Your Ref: OWPC21196
Our Ref: M/155/18/PL 18-12-2018
Please ask for:
Mrs A Gardner

Replacement dwelling (resubmission following M/114/18/PL).
5 Central Drive Middleton-On-Sea

Thank you for your internet representation made on 22nd January 2019 which has been recorded as '**an objection**' with the comments as follows:

PROJECT TITLE Proposed development at 5 Central Drive	DRAWING TITLE Proposed Elevations		No	REVISION	DATE
	STATUS Planning Application				
	SCALE 1:100 @ A3	DATE 14.12.2018			
	DRAWN BY AP	DRAWING No PA-270-07

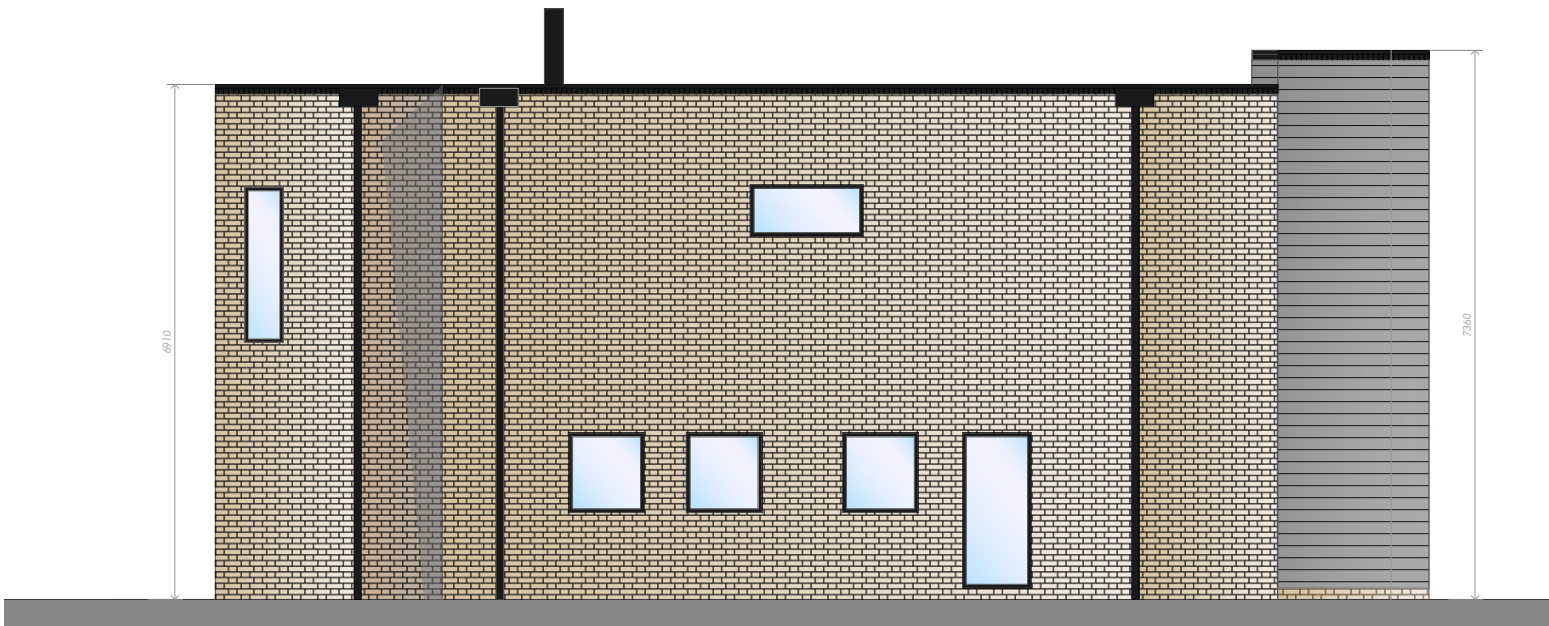
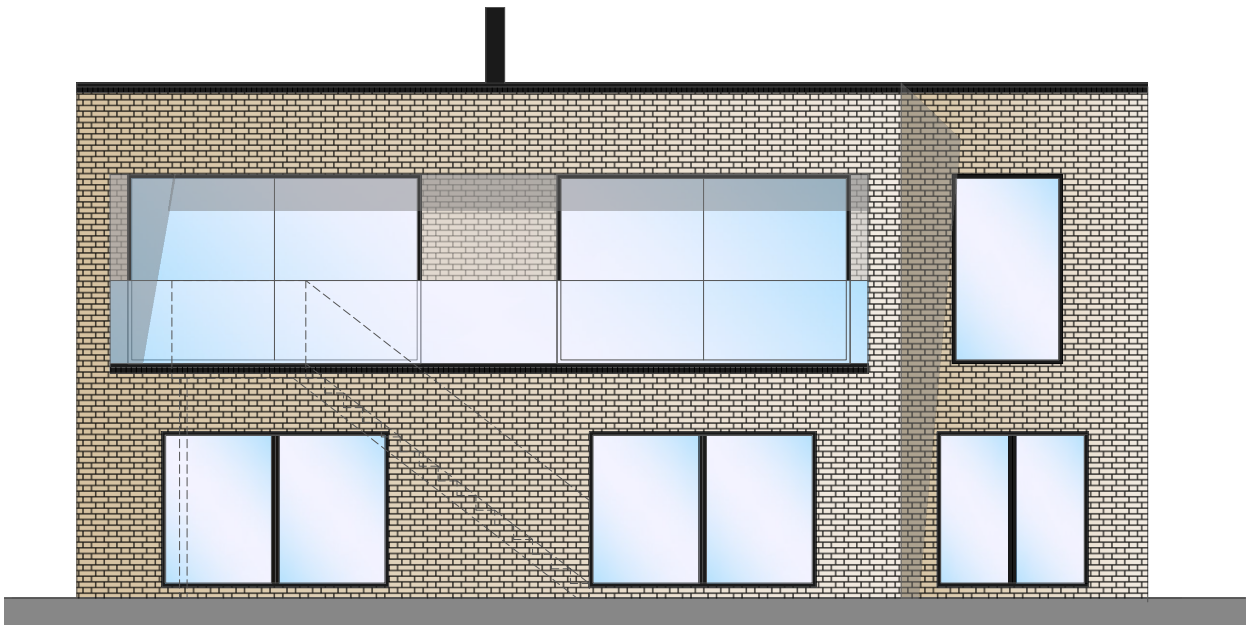
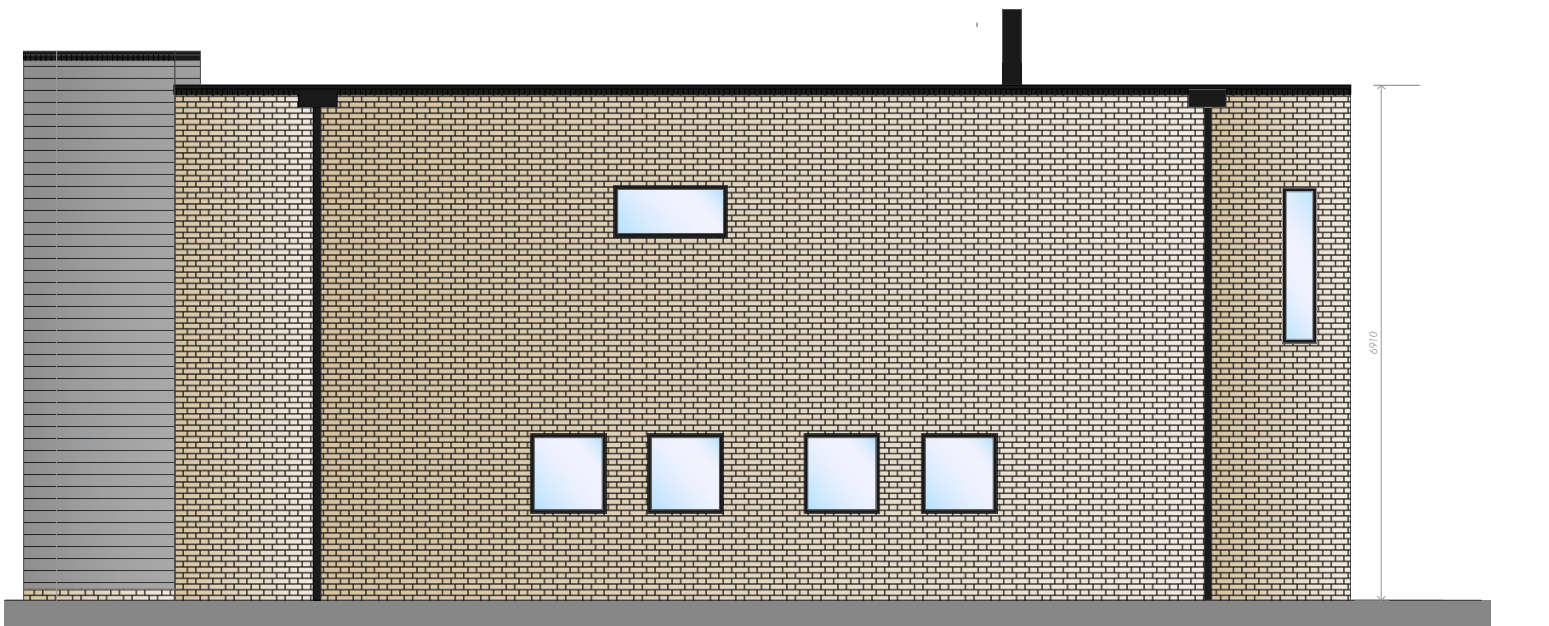
My wife and I are concerned by the proposed design of the new property. the basis of our concerns are that the design neither fits in nor is it similar or complementary with other properties in the neighbourhood. The Elmer sands estate is a conventional coastal area of traditional residential properties and which are of typical seaside and design many of which are of the upside down concept. A large number of the properties appear to have been built between the 1920s and the 1940s and were of the design of that era and this represents the tone and feeling of the area. The applicant has failed to demonstrate that the replacement dwelling positively responds to its immediate surroundings to create a visually pleasing dwelling. The use of brown bricks does not blend in but instead looks out of place.

I dispute the assertion that flat roofs are a common sight when there are only a handful of flat roof properties in the neighbourhood. I refer to the applicant's comment that the proposal is a flagship design for the area and that it will no doubt encourage similar schemes to be adopted: this affirms in my view that the development does not fit in and is different

In summary the proposal is too extreme and has little in common with its neighbours which generally have a maritime influence through common usage of cladding decking masts etc

The design is contemporary and not in keeping with the area. It is not visually pleasing to its immediate surroundings and will stand out as an eyesore and contrary to the applicant's assertion that it will be sympathetic to the neighbourhood
